Our Ref: R/252/17/T

I have just received Arboricultural comments regarding your application for tree surgery at various locations throughout the Sea Estate, Rustington.

SEA ESTATE RUSTINGTON
 PROPOSED WORK TO TREES WITH PRESERVATION ORDERS (TPO'S)
 2017 - 2018
 REFER TO TABLE FOR SCOPE OF WORK

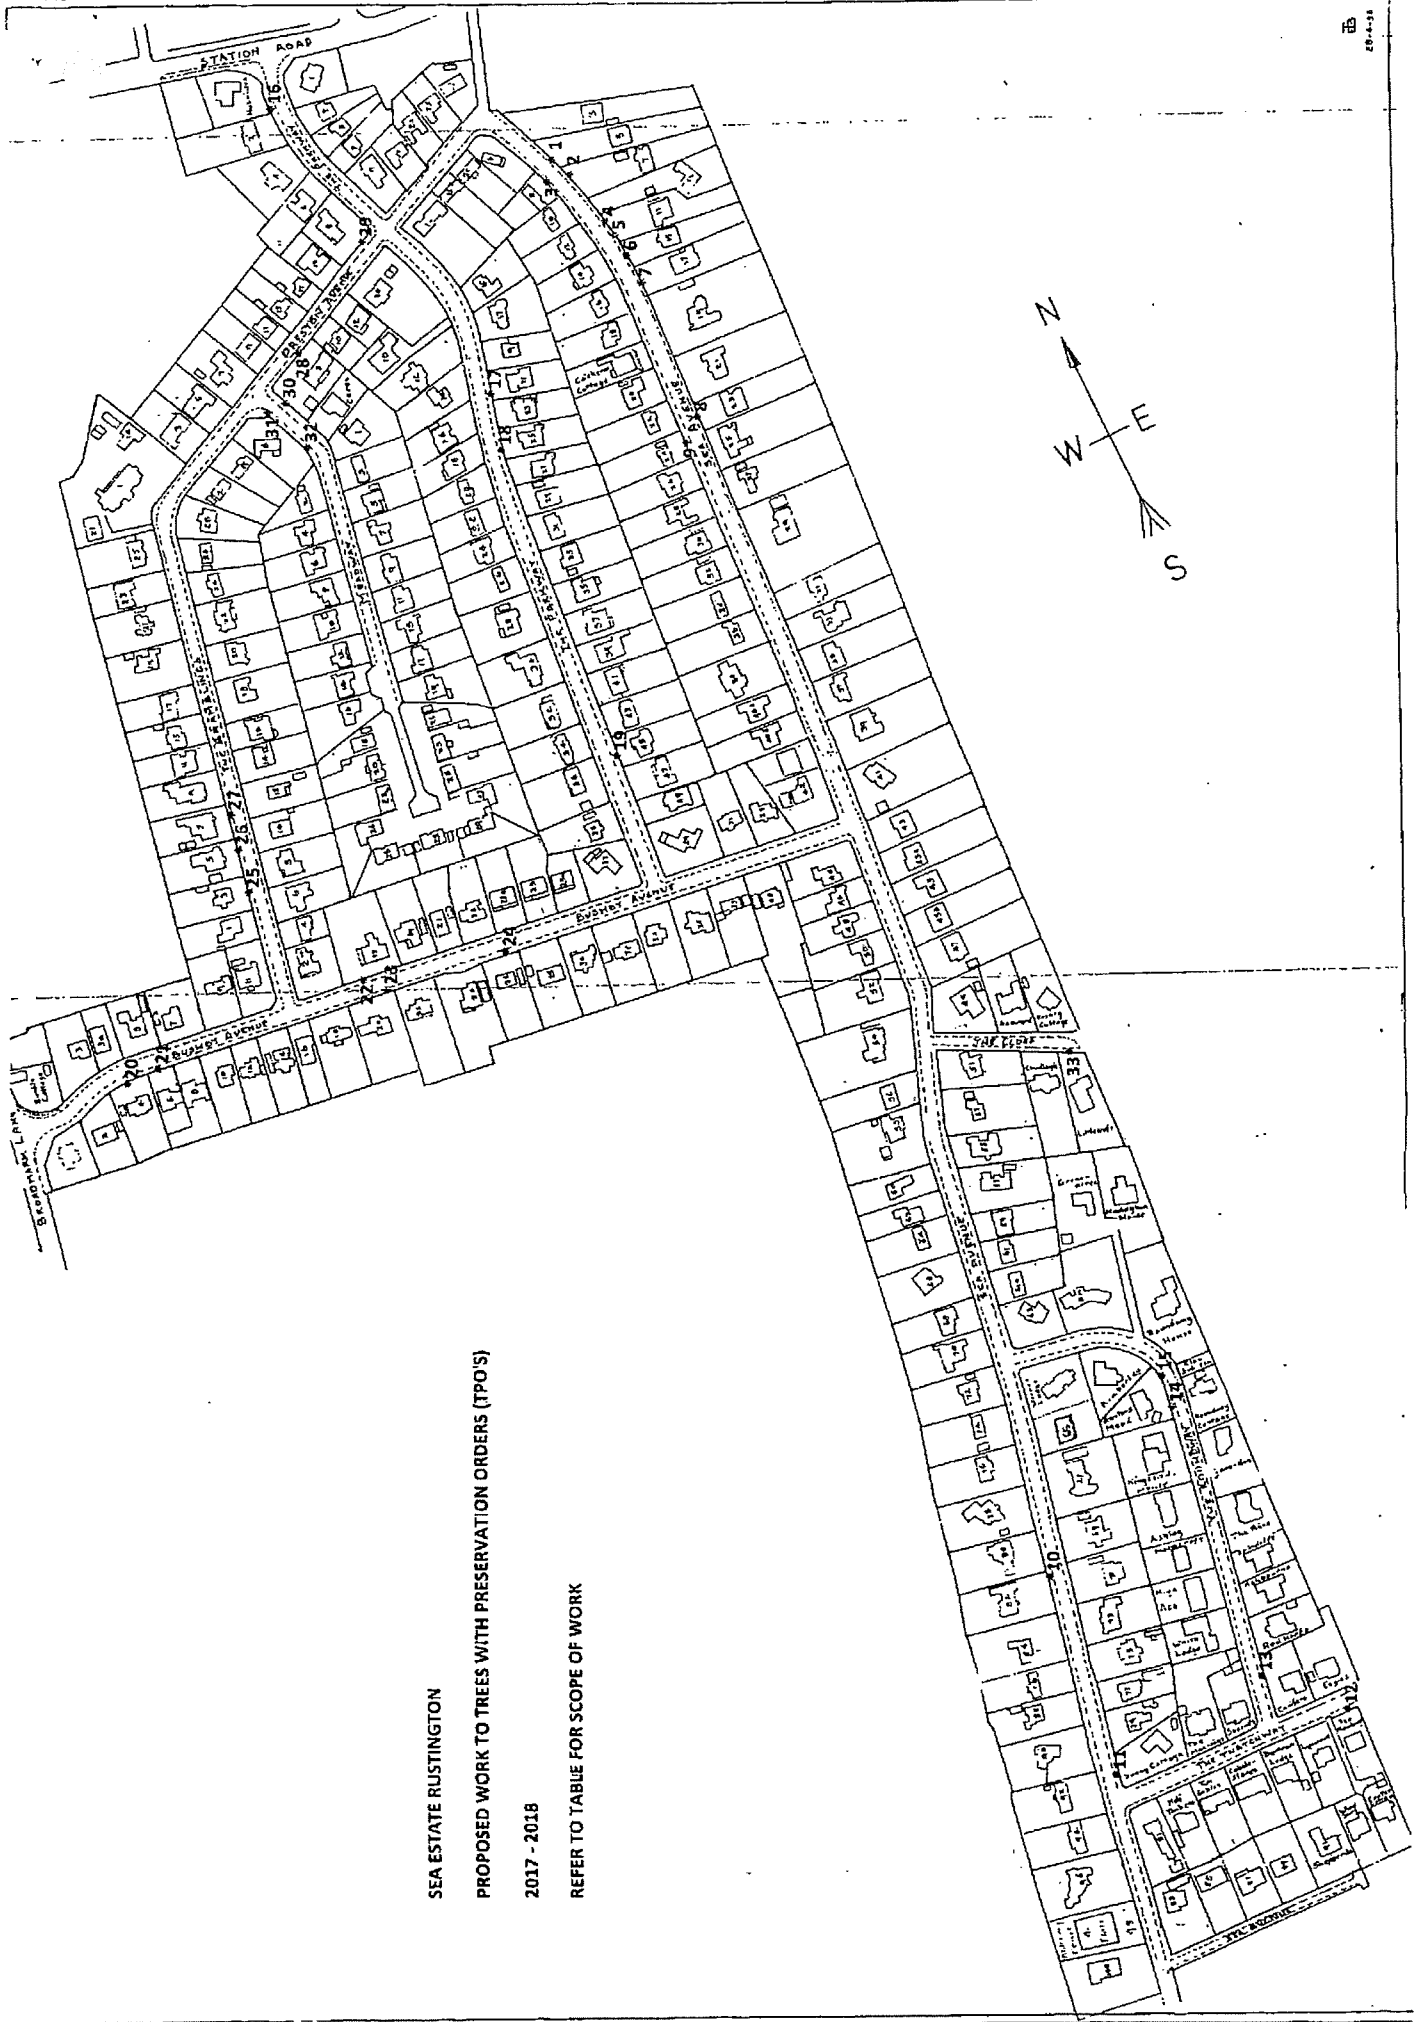
As it stands, the application is set to be refused as it is believed that the works would undermine the amenity value of trees 8,9,21,25,26,27,29,30,31.

Do you accept the change in description to trees 8,9,21,25,26,27,29,30,31?

- 8 – Crown lift by removing only the two lowest whorls of branches.
- 9 – Crown lift by removing only the lowest whorl of branches.
- 21 – Crown lift to 4m over road and 2m in all other directions.
- 25 – Reduce the three lowest branches facing west by a maximum of 1m.
- 26 – Reduce the lowest west facing branch by a maximum of 1m.
- 27 – Reduce the five lowest west facing branches by a maximum of 1m.
- 29 – Crown lift to 5m removing only branches up to 4cm in diameter.
- 30 – Crown lift to 3m on road side only by removing branches less than 5cm in diameter.
- 31 – Crown lift to all sides by 2m only removing branches up to 4cm in diameter.
